CITY OF ALBUQUERQUE

RE: Murphy Express – 1358 Wyoming Blvd
Grading Plan
Stamp Date: 11/15/17
Drainage Report
Stamp Date: 11/27/17
Hydrology File: J20D037

Based upon the information provided in your submittal received 12/27/17, the Grading Plan and Drainage Report **is not** approved for Building Permit. The following comments need to be addressed for approval of the above referenced project:

GRADING PLAN

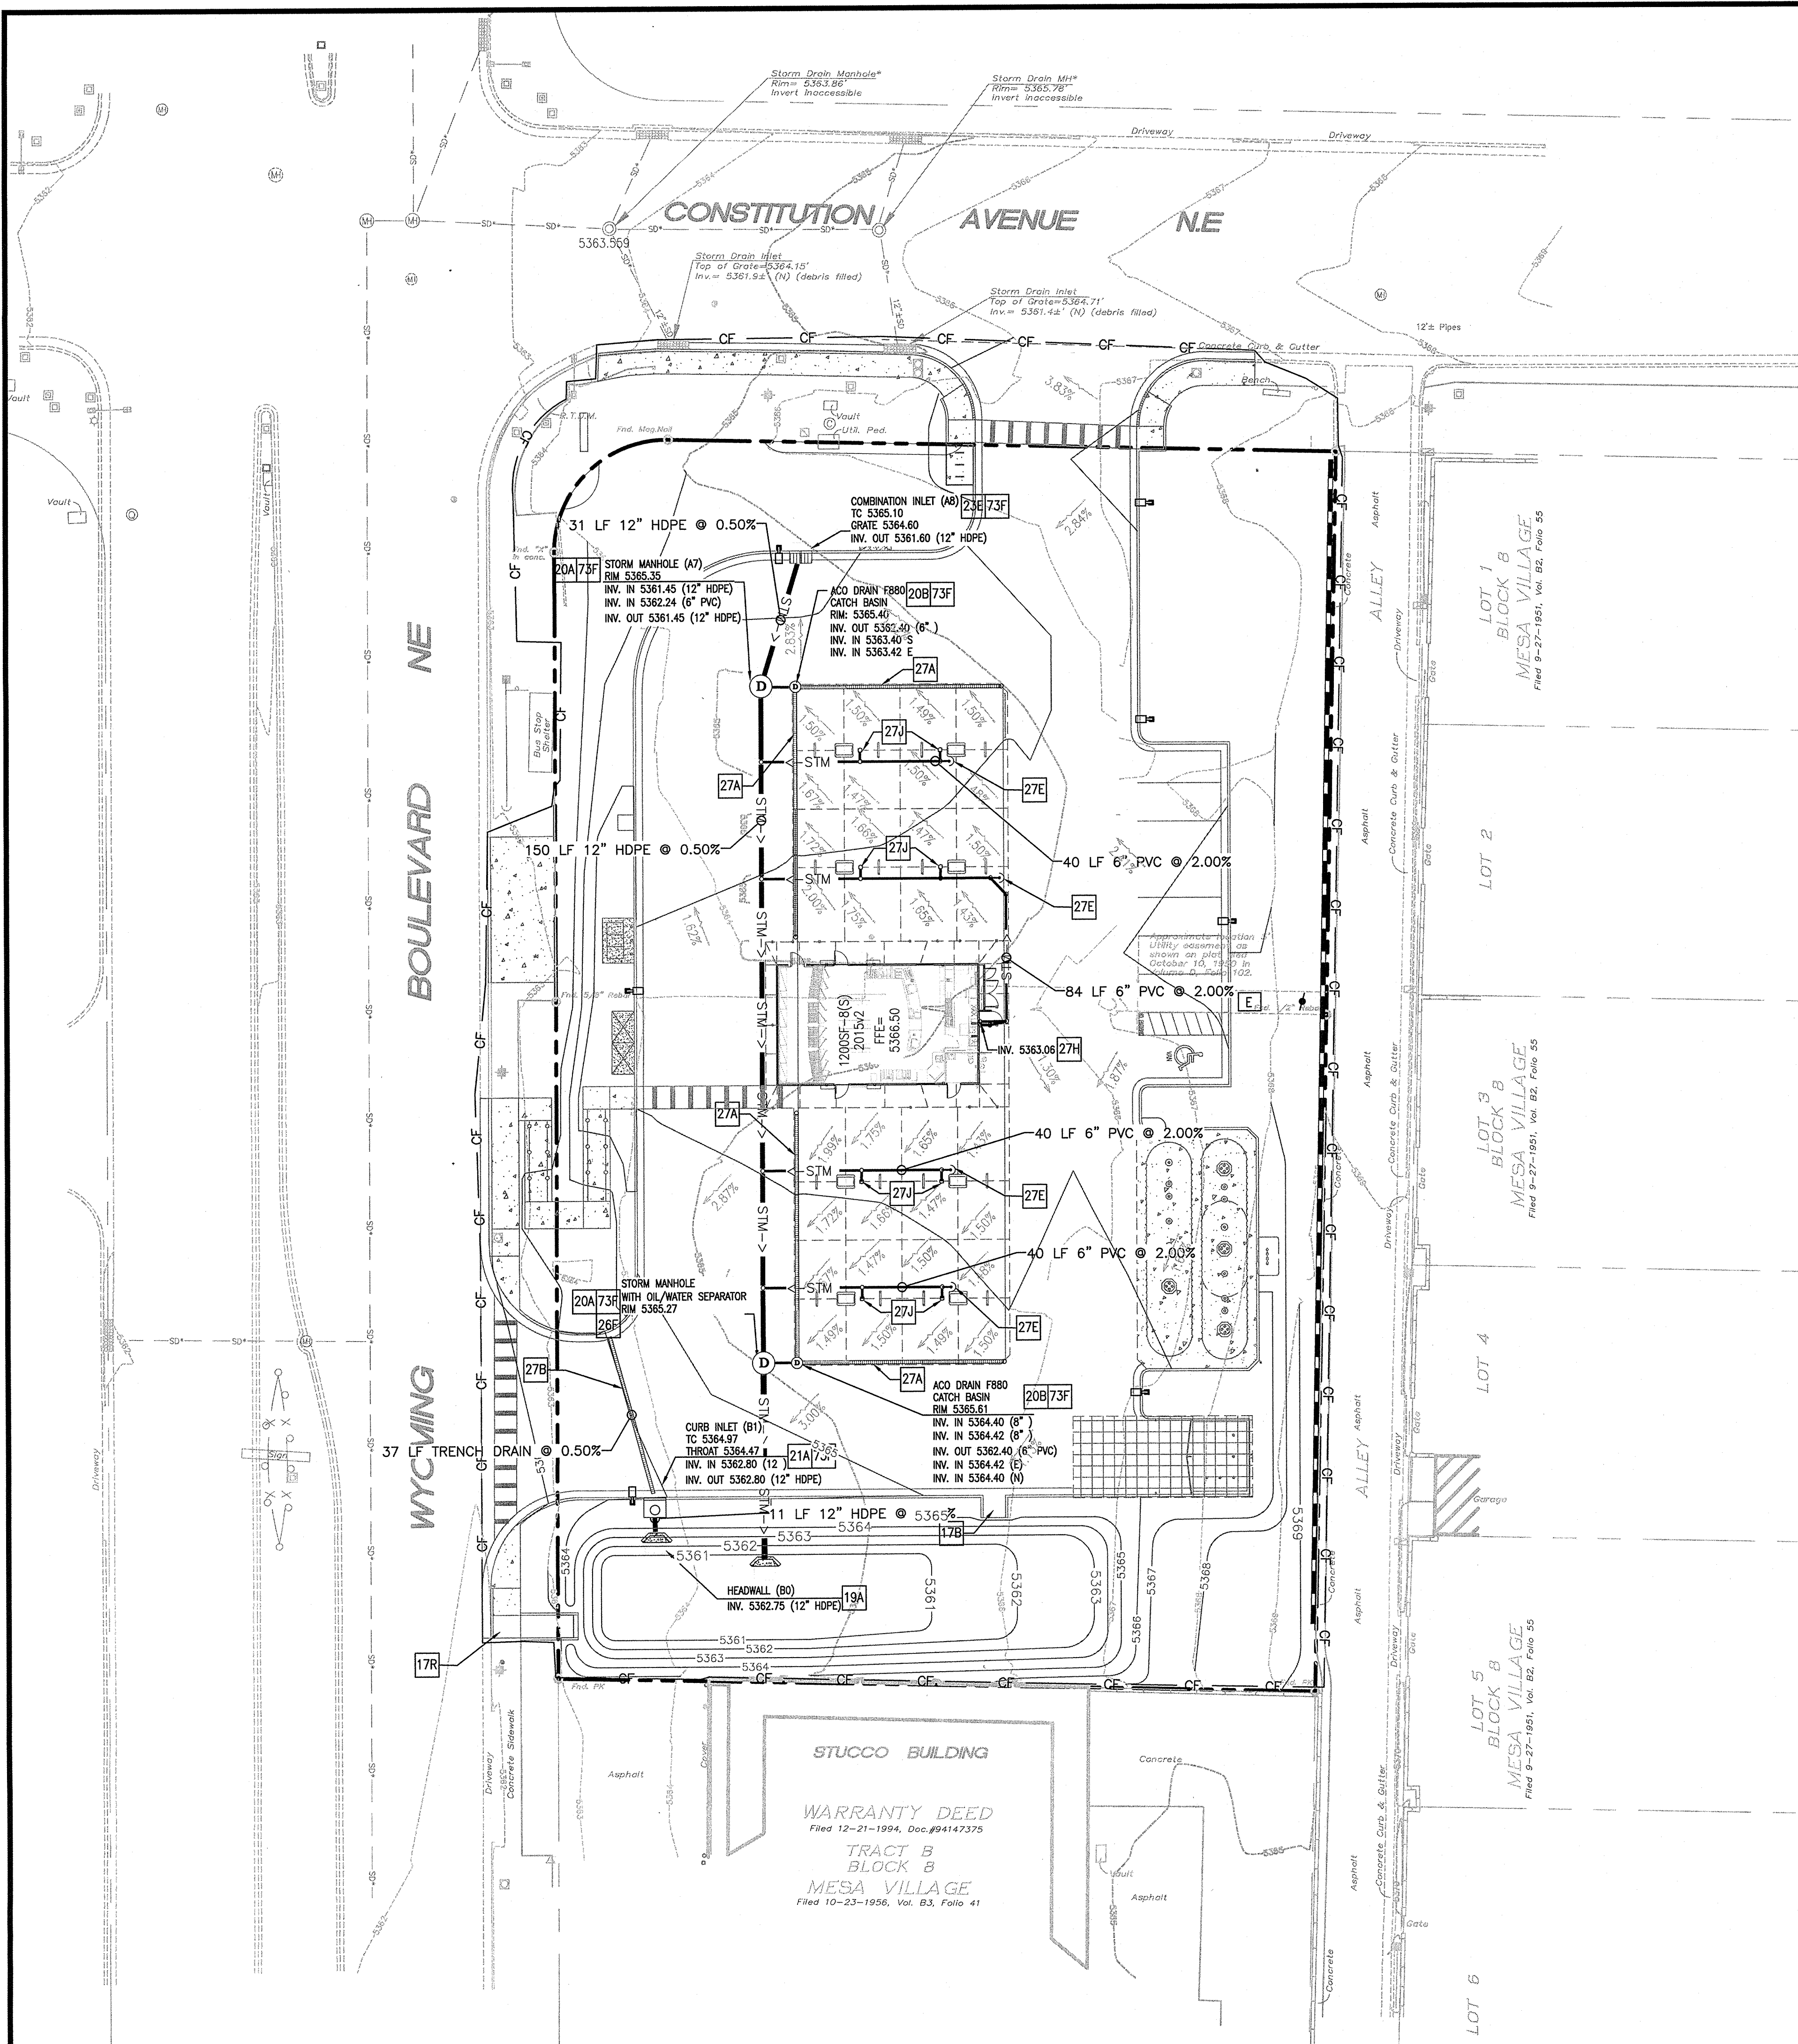
1. Please provide the benchmark information for the survey contour information provided.
